From: Laura Gibbons
Sent: 21 March 2019 09:21
To: Planning.Responses
Cc: Simon Davis
Subject: RE: Planning Consultation on Y/21/19/DOC

Engineers Comments Regarding Condition 9- surface water drainage design

APPLICATION NO: Y/21/19/DOC

Site Address: Land East of North End Road Yapton BN18 0AG

Typical 575mm (max) high retaining wall section 1:20
(see site plan for locations)

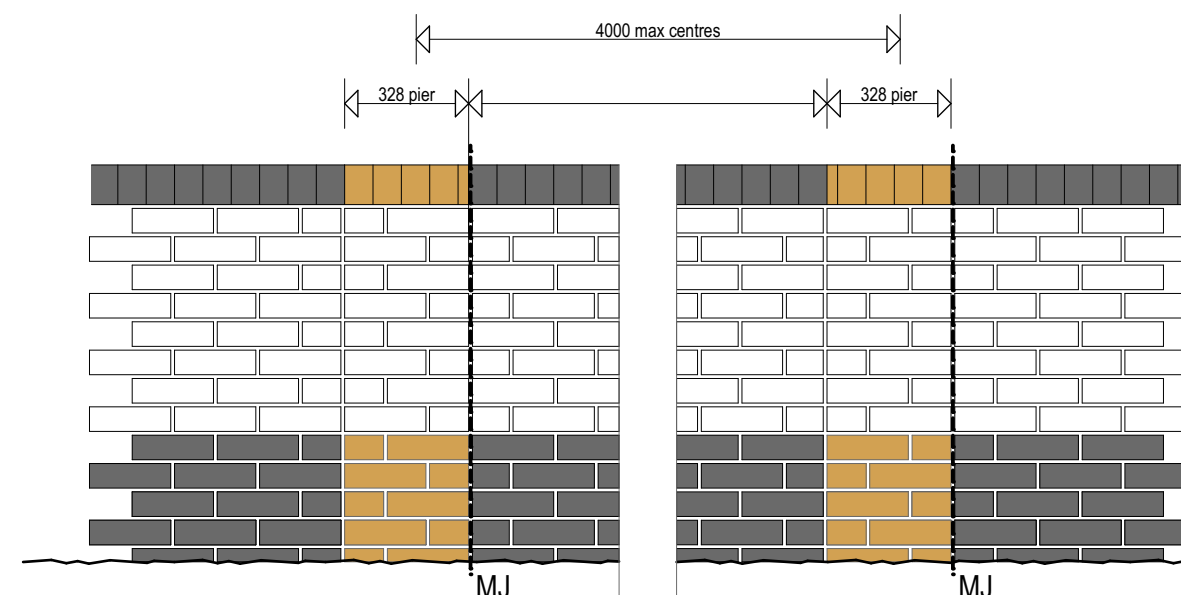
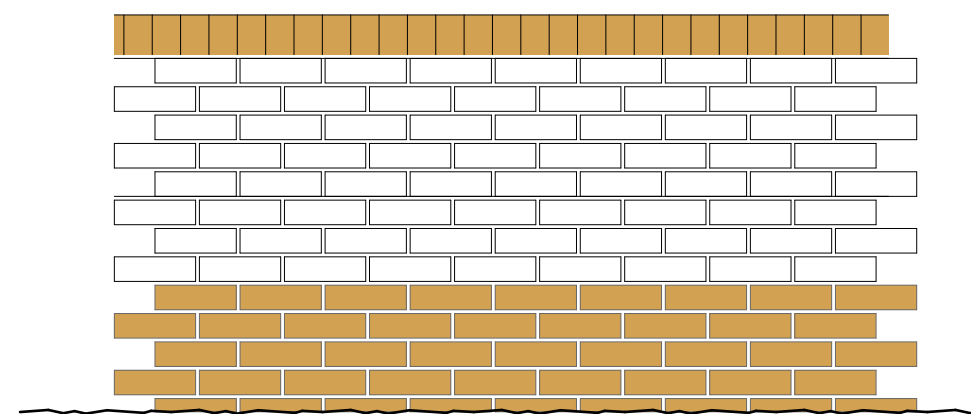
Please provide details of the proposed retaining walls, and in particular the drainage associated with these.
